SSD 6011 - Mixed use residential development within the South West Plot

Submission by:

Greg Seeto

29 July 2013

## Winter Solstice (21<sup>st</sup> June)

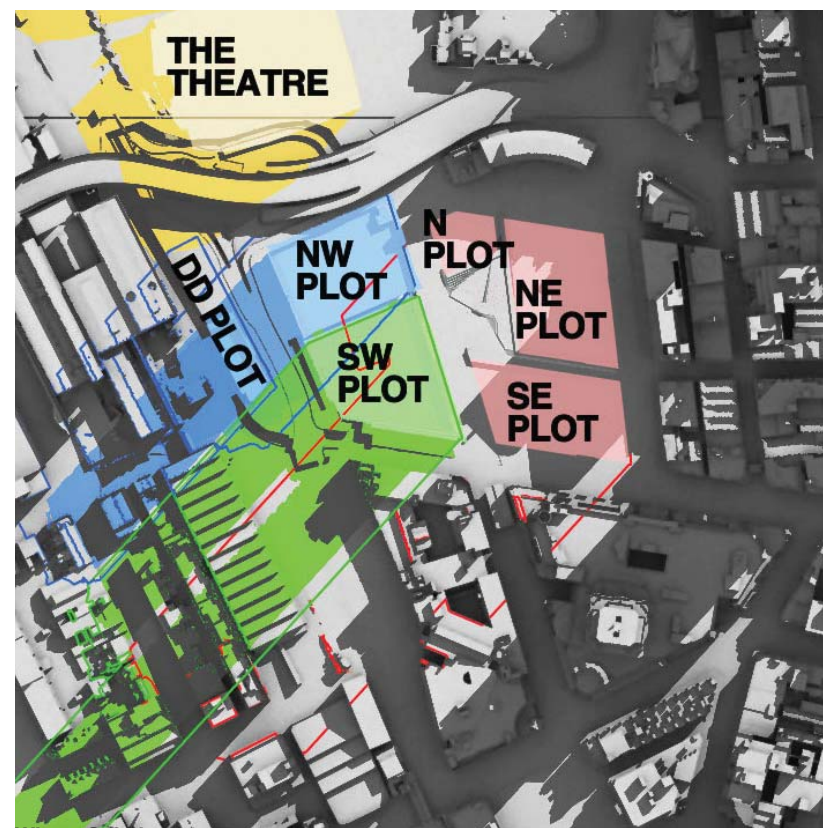
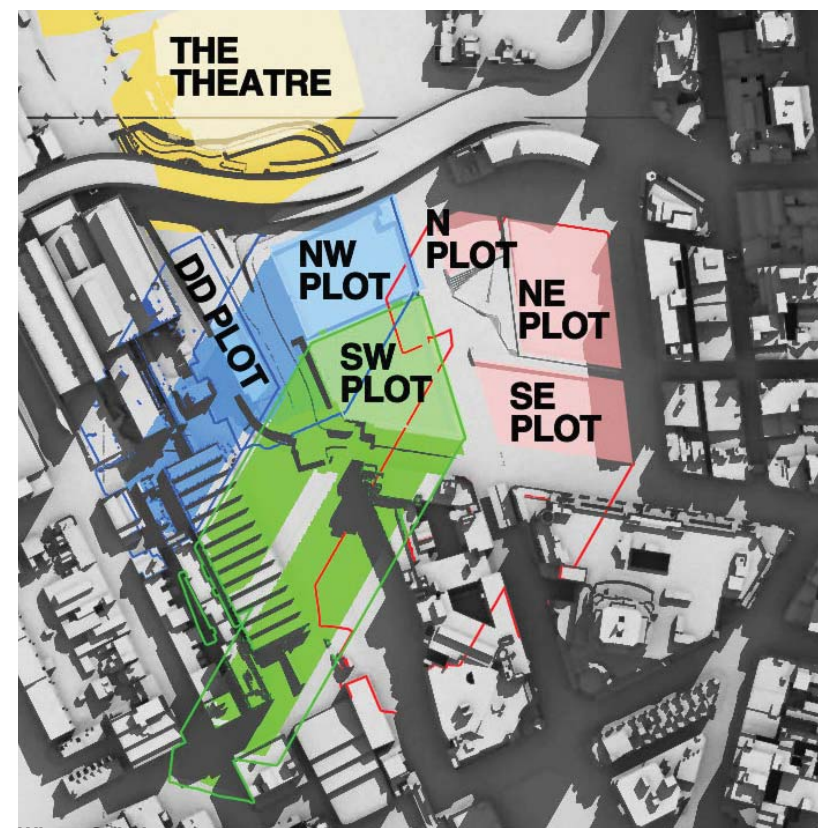
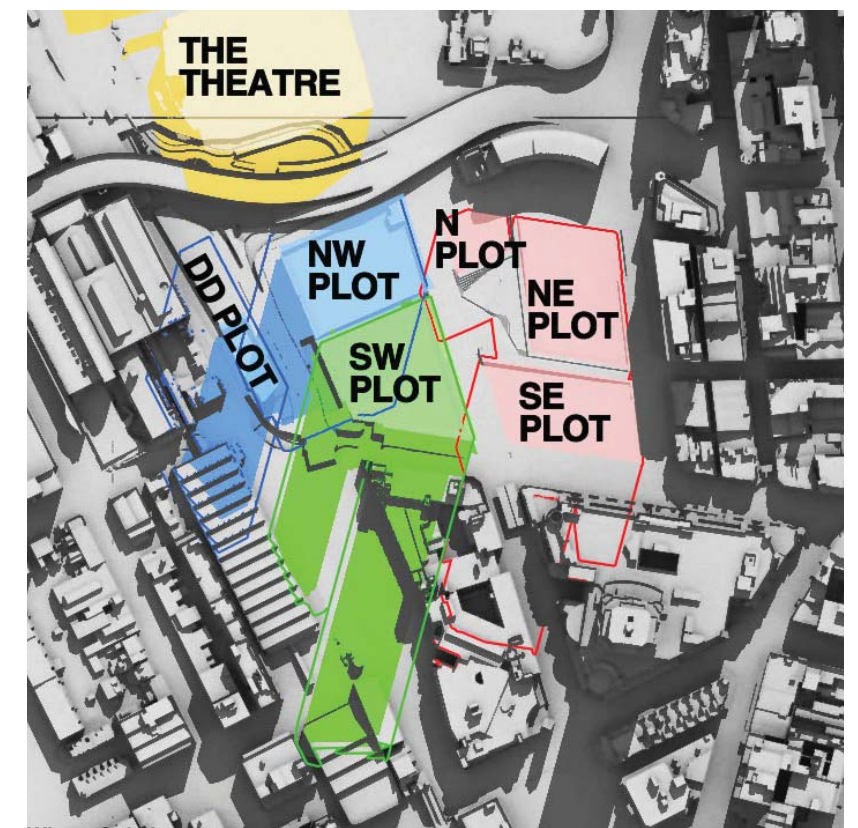
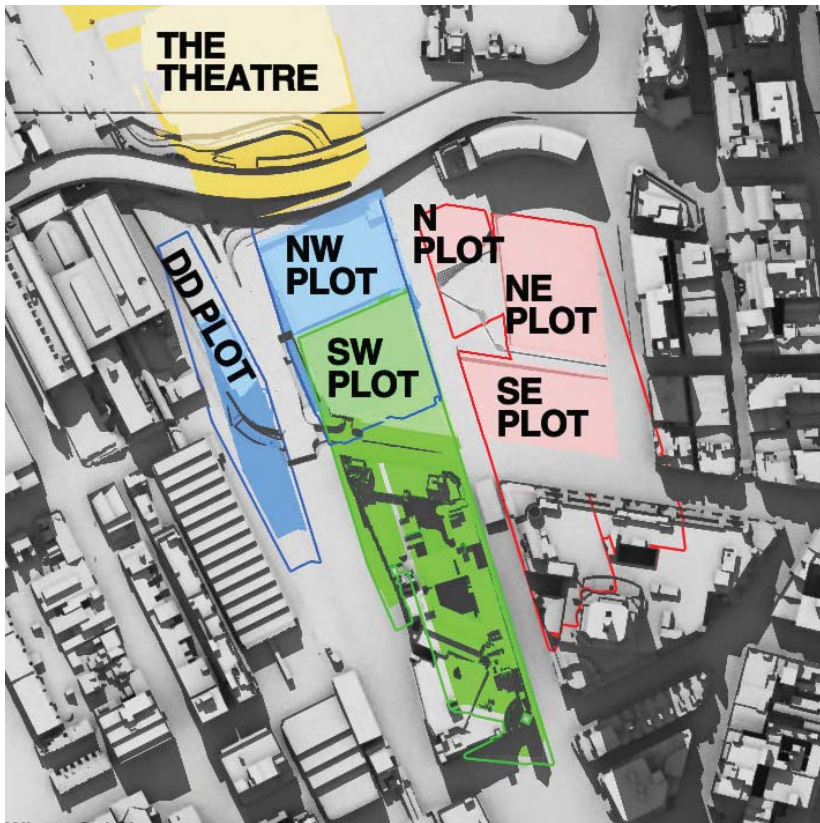
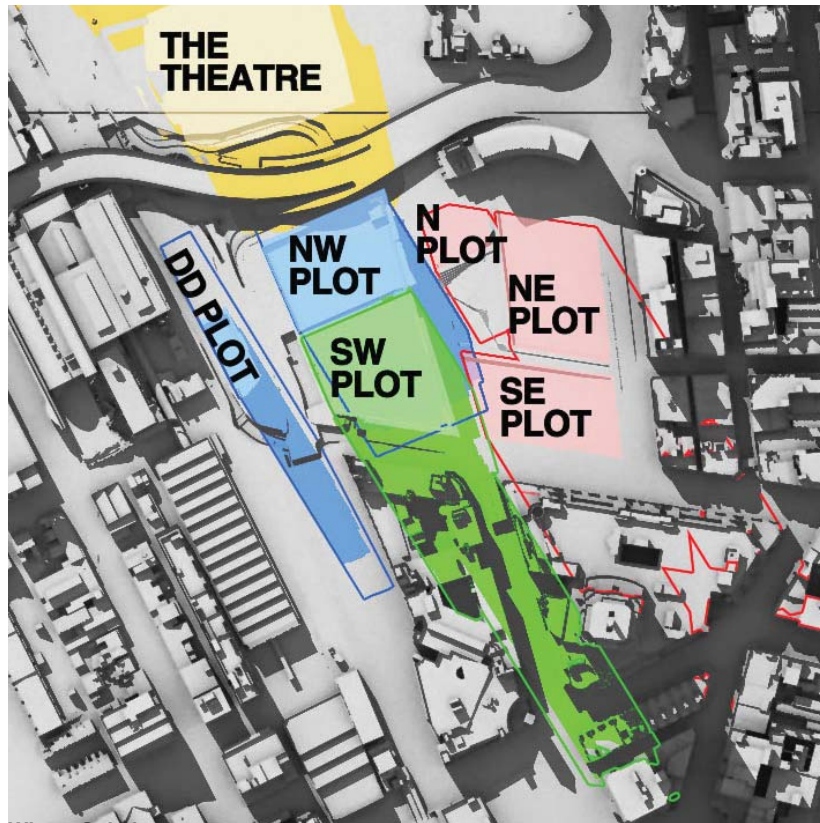
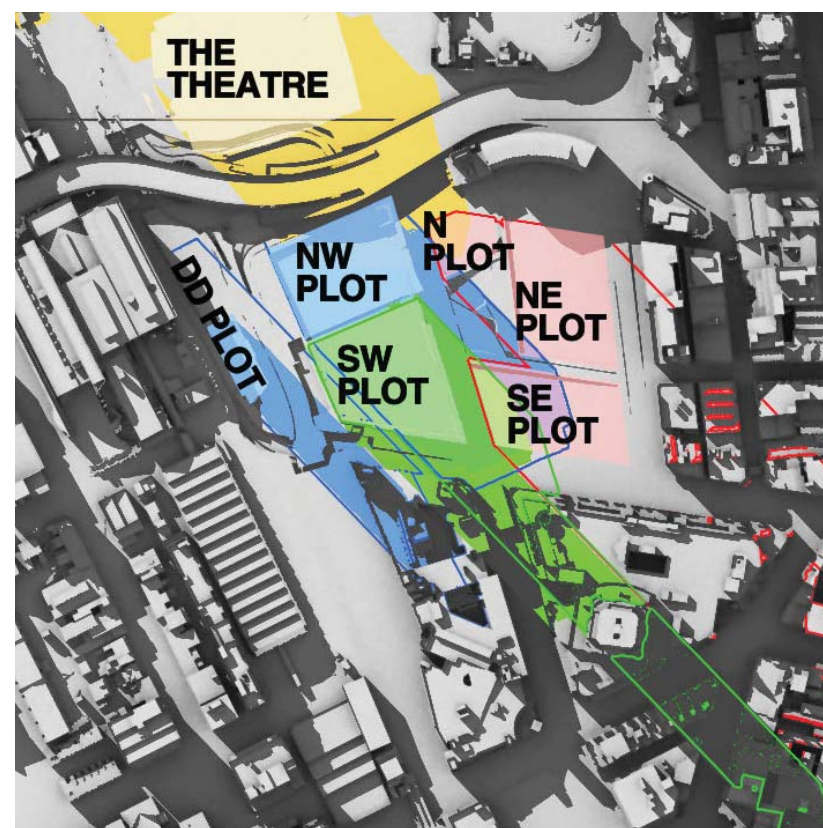
We refer to the shadow diagrams in SSD5878, Appendix H. Supplementary Design Report, Section 6. Amendments, Winter solstice - 22 June. This is not 21 June, but there would be no noticeable difference.

At 9am, 10am and 11am the west façade is totally in shadow due to other parts of The Peak building itself.

At 12pm there is still substantial existing shadowing on the west façade caused by the irregular shape of the west facade.

At 1pm the existing shadowing has been substantially removed, but not totally removed.

It can be concluded that some single aspect apartments on the west façade and some south-west dual aspect corner apartments currently receive less than 2 hours direct sunlight to habitable rooms and 50% of the private open space between 9am and 3pm on 21 June.

By 2pm the existing shadowing has been totally removed, but that is too late to achieve two hours of direct sunlight before 3pm.

At 9am, 10am and 11am the west façade is totally in shadow due to other parts of The Peak building itself.

At 12pm there is still substantial existing shadowing on the west façade caused by the irregular shape of the west facade.

At 1pm the existing shadowing has been substantially, although not entirely, removed. However, overshadowing of lower levels of the west façade by the concept proposal parameter plan shadows for the N,NE and SE plots has already started.

By 2pm the existing shadowing has been totally removed. However, overshadowing of the west façade by the SSDA4 and SSDA5 buildings has appeared and risen further up the west façade than the concept proposal parameter plan shadows for the N,NE and SE plots, which is still present.

At 3pm, the proponent states correctly that 45-45% of the western façade is overshadowed by the SSDA4 and SSDA5 buildings.

It can be concluded that, as a result of combination of the proposed development with existing shadowing of the west façade, some single aspect apartments on the west façade and the south-west dual aspect corner apartments which currently receive less than 2 hours direct sunlight to habitable rooms and 50% of the private open space between 9am and 3pm on 21 June will suffer additional overshadowing. It is beyond our skills to count the number of such apartments. We note that the proponent has made no attempt to do so.
